The Planning Inspectorate  
M23 junction 10 / A3 Wisley Interchange

I am the County Commissioner for Girlguiding Greater London West and we own Heyswood Campsite which is being affected by the M25 junction 10 / A3 Wisley Interchange Improvement Plan.

Our Response to the DCO

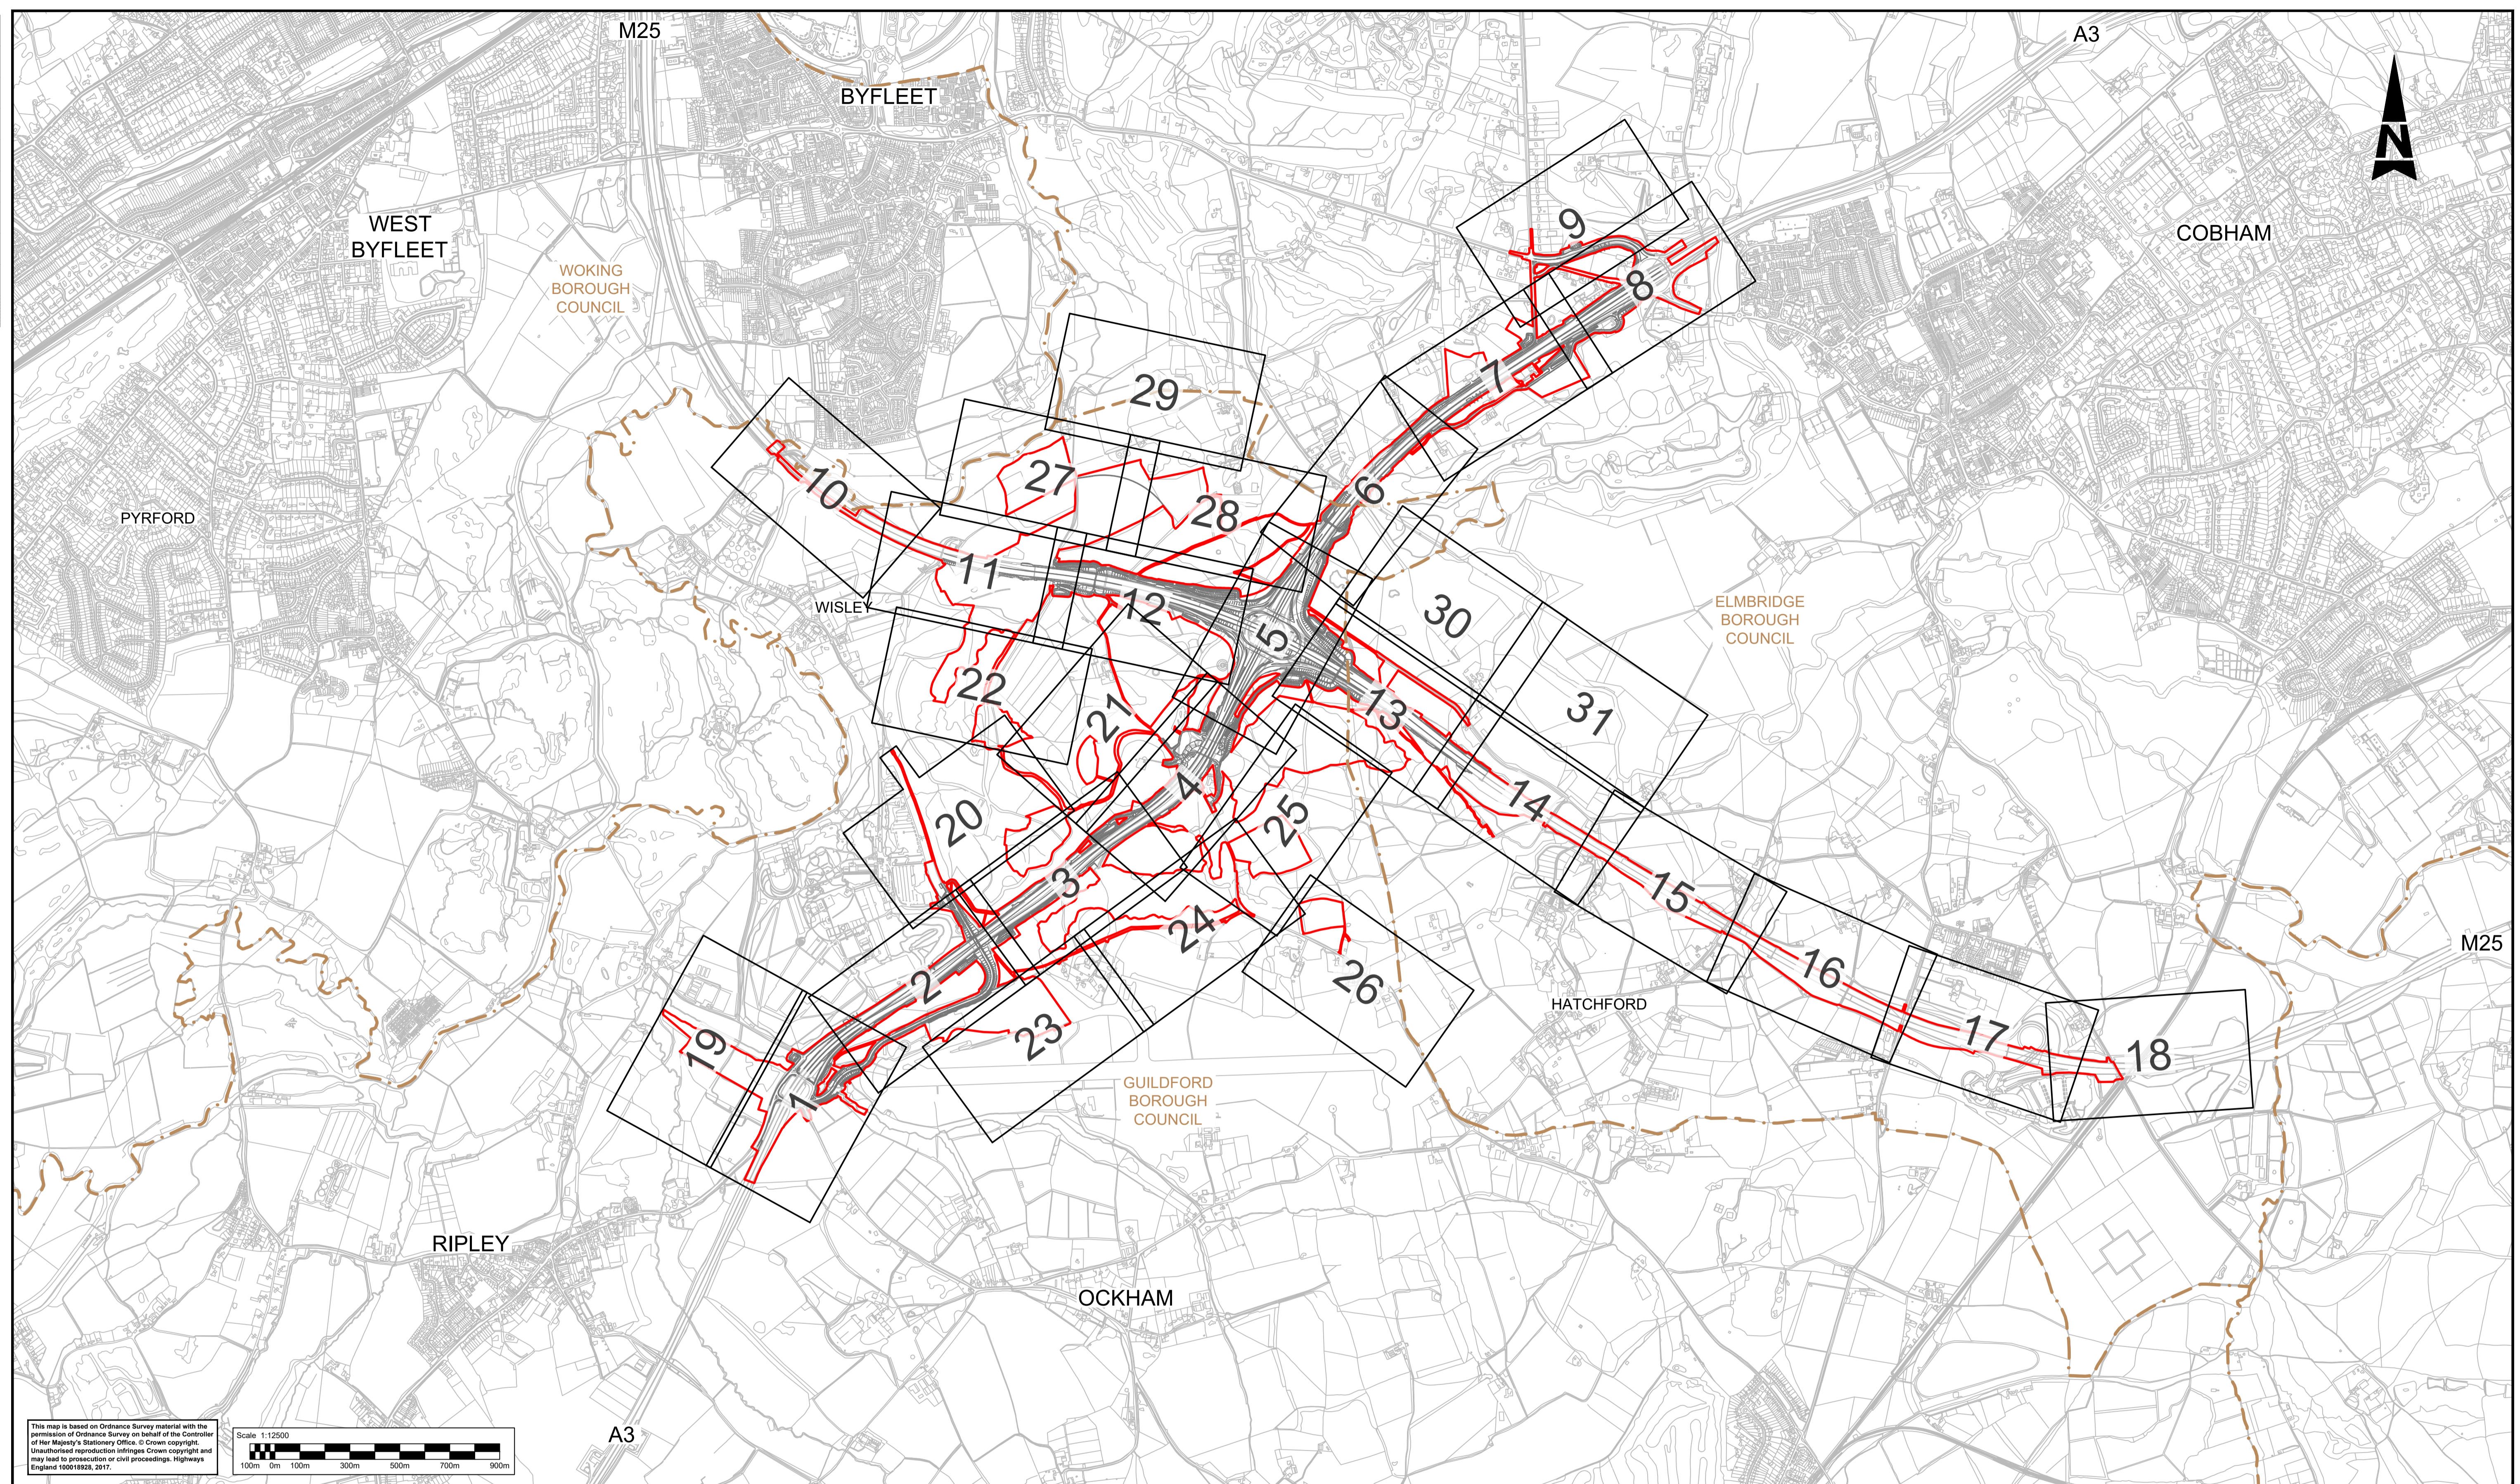
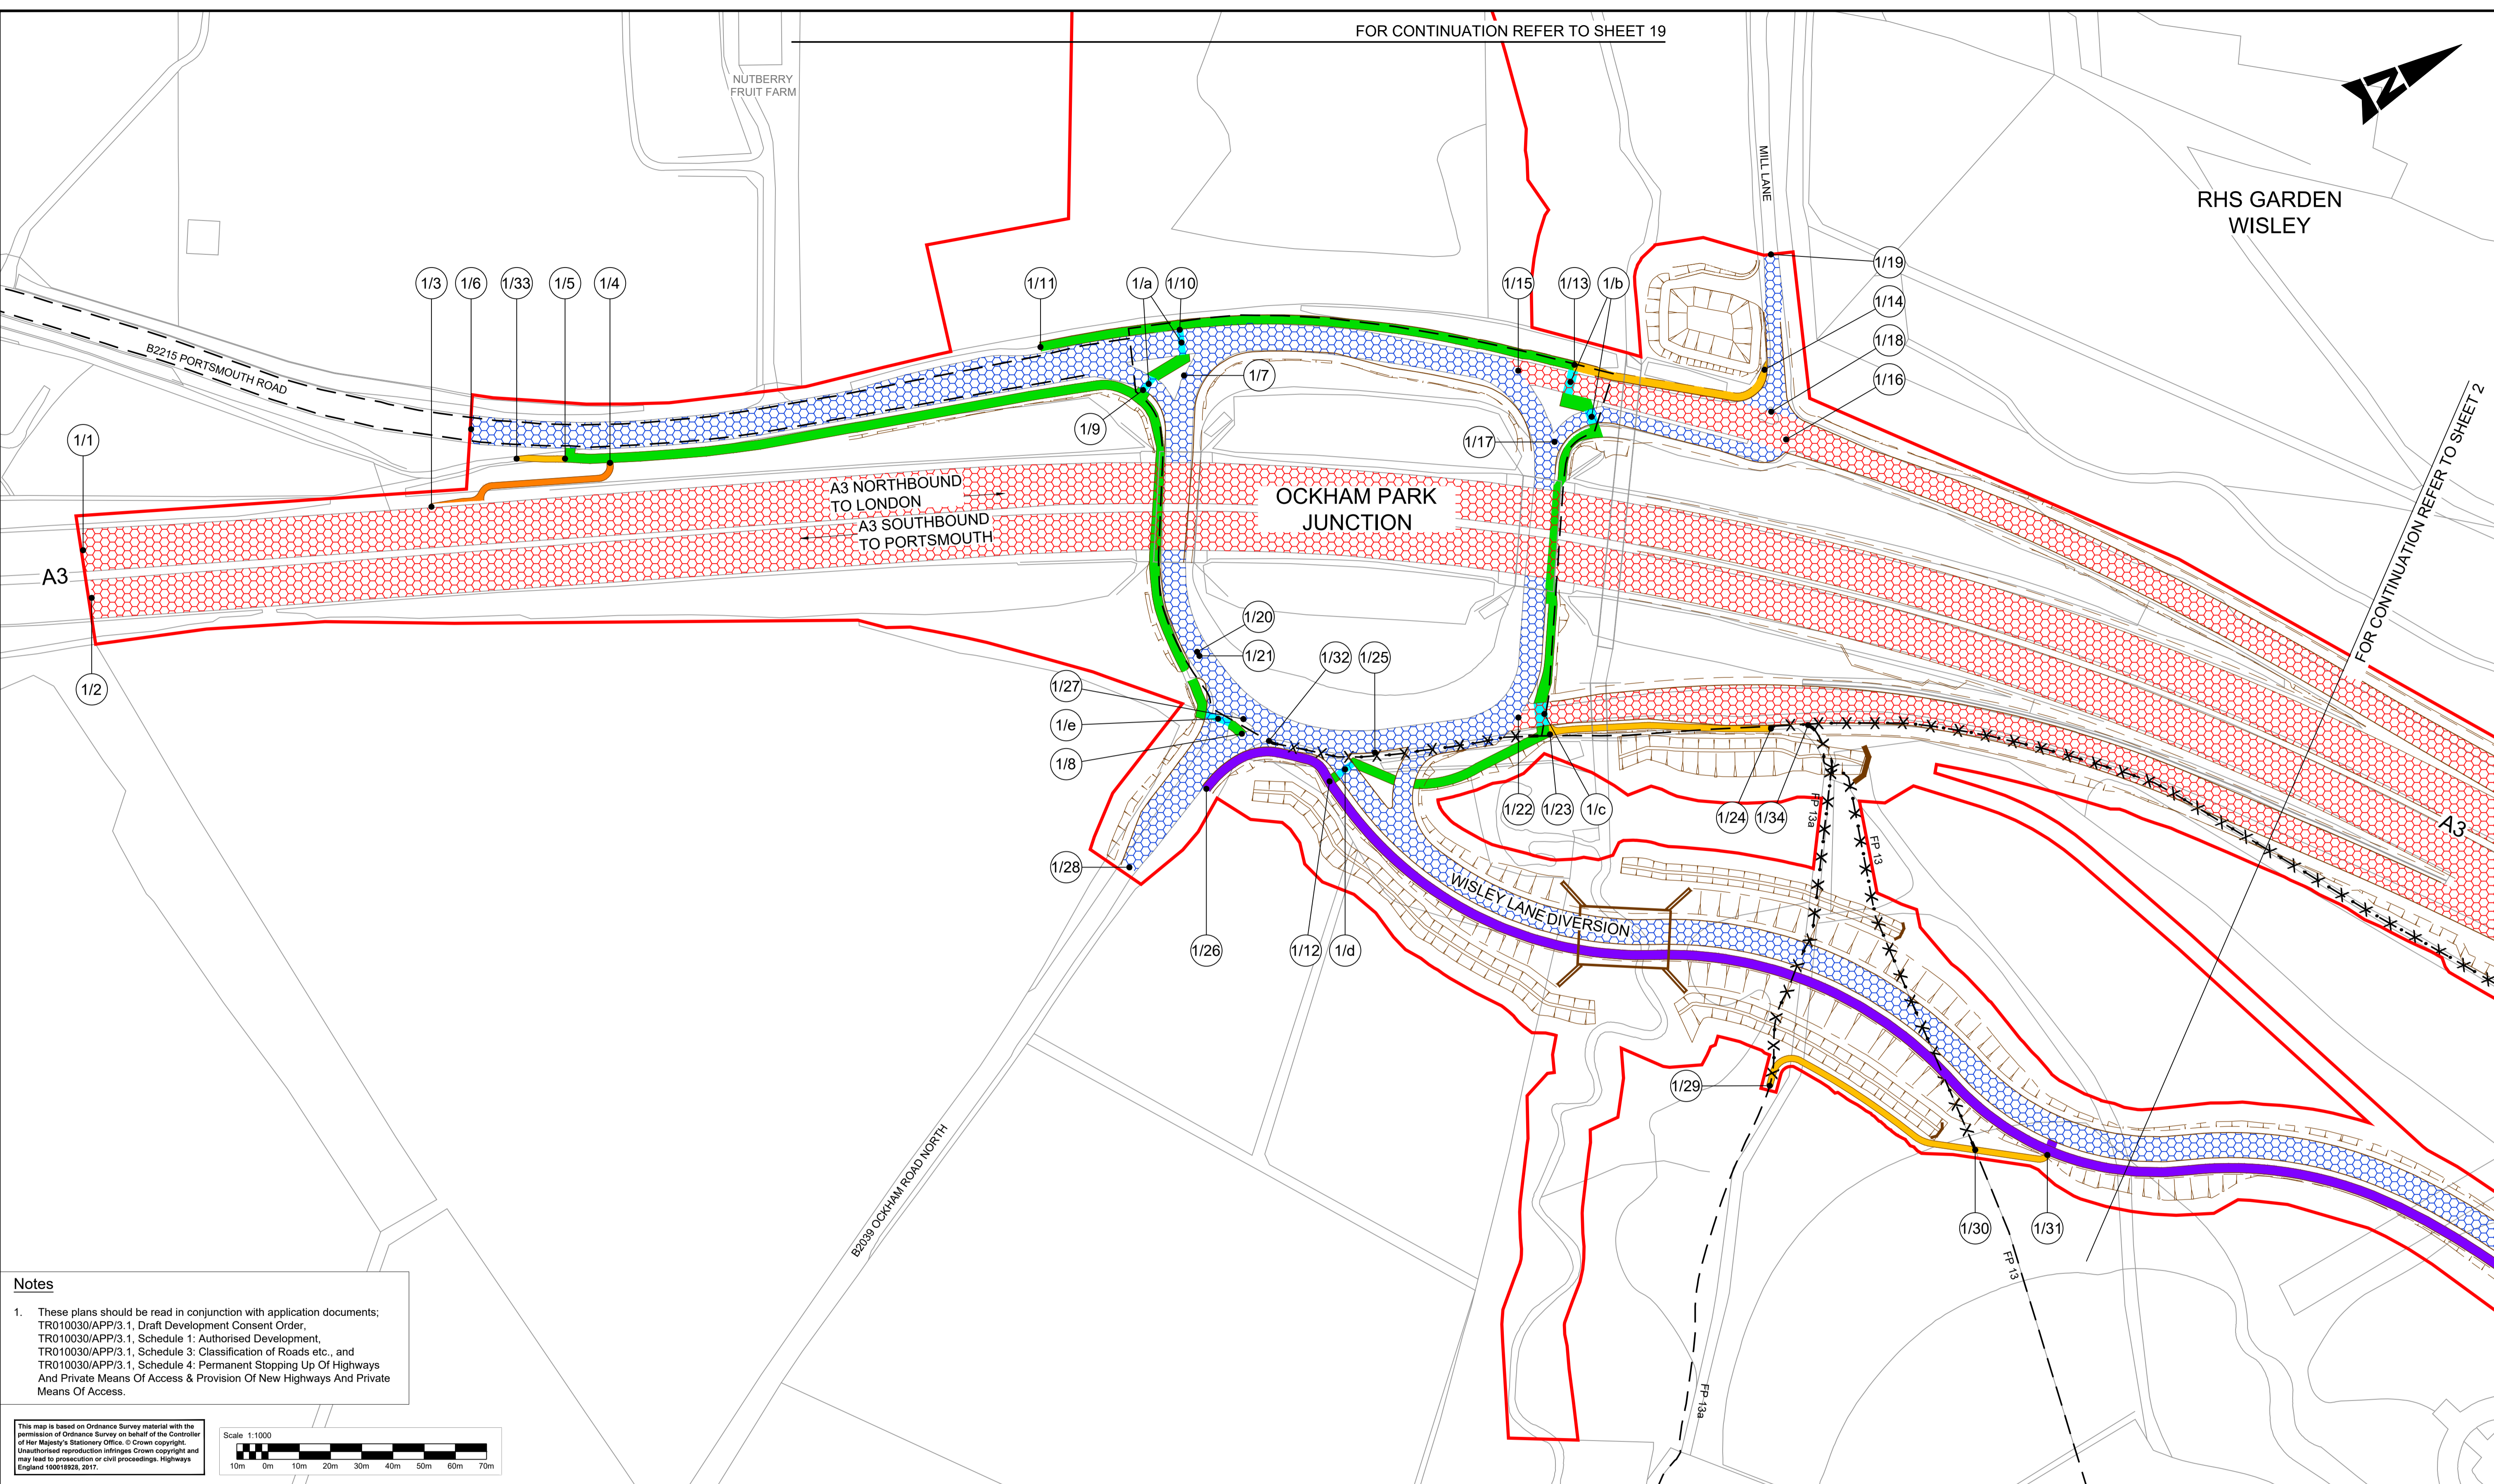
- The map showing the new road proposal across our land is inaccurate. It is inaccurate in that the current track is inaccurately marked. This makes it difficult to be sure where the new road is proposed.

- The map also shows, fencing on both sides of this road, yet when we queried this with Highways England and Atkins, they indicated that they had not intended this to be the case so they were not sure why this is showing.

- We have asked for the width of the track to both be minimised and as close to the current track as possible to ensure that trees are not felled unnecessarily. Currently the mature sweet chestnut that is of regional significance is showing as being felled as it is within the new road proposal.

- We have asked for the security gates at the east end of the site to be moved to the boundary as we will continue to need to access buildings alongside our eastern boundary.

- There are a number of symbols on the maps that are not included in the legend and we have asked Atkins/HE for clarification e.g. triangle with CO2, blue circles.

- We have two cess pits on our site near the A3, which service all the buildings on site, and it is still unclear whether these are within the land affected by the DCO or not.
